DRAINAGE INFORMATION SHEET

PROJECT TITLE: GROSSMAN BUILDING ZONE ATLAS/DRNG. FILE #: H-14 / 1182

RE: Drainage Plan for Grossman Building (H14-D82) Engineer's stamp dated 9/17/96

S-1

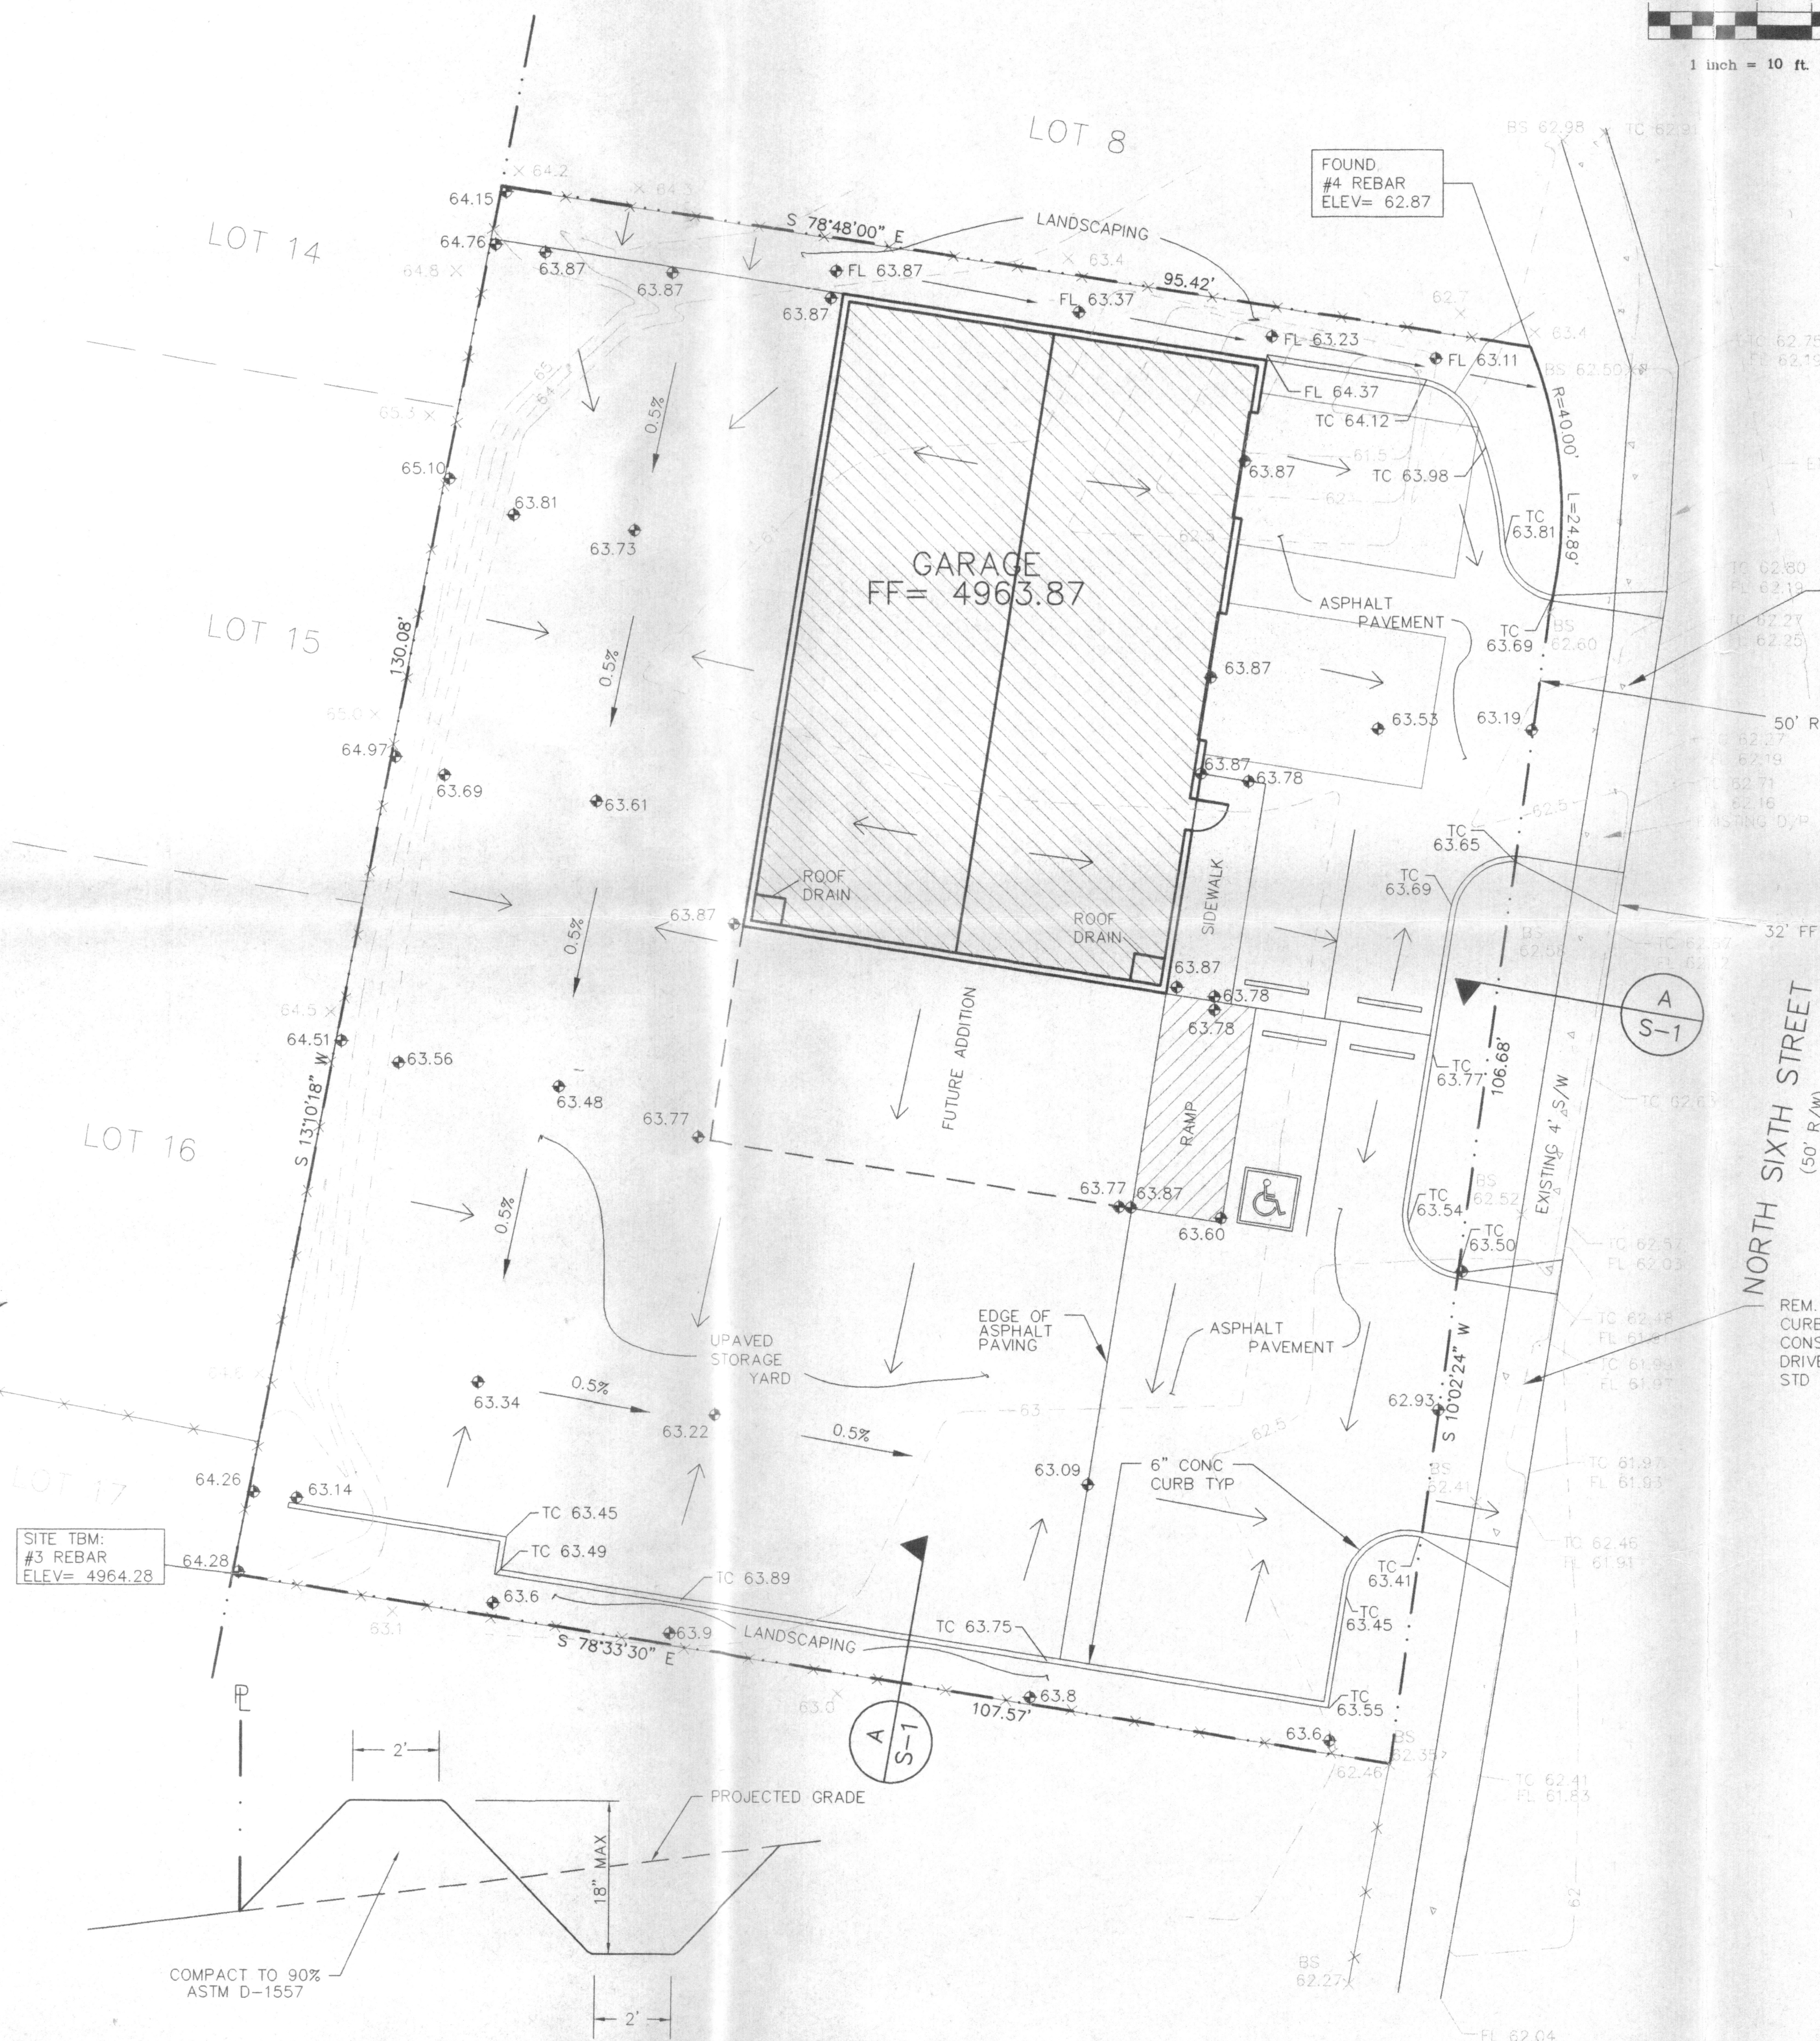
Based on the information provided on your September 17, 1996 submittal, listed are some concerns that will need to be addressed prior to final approval:

1. Location & direction of roof drains.
2. More top of curb & flow line elevations on North Sixth Street.
3. Identify the slopes on the proposed swales to convey the runoff.
4. What C.O.A. Benchmark was used to set the T.B.M.?
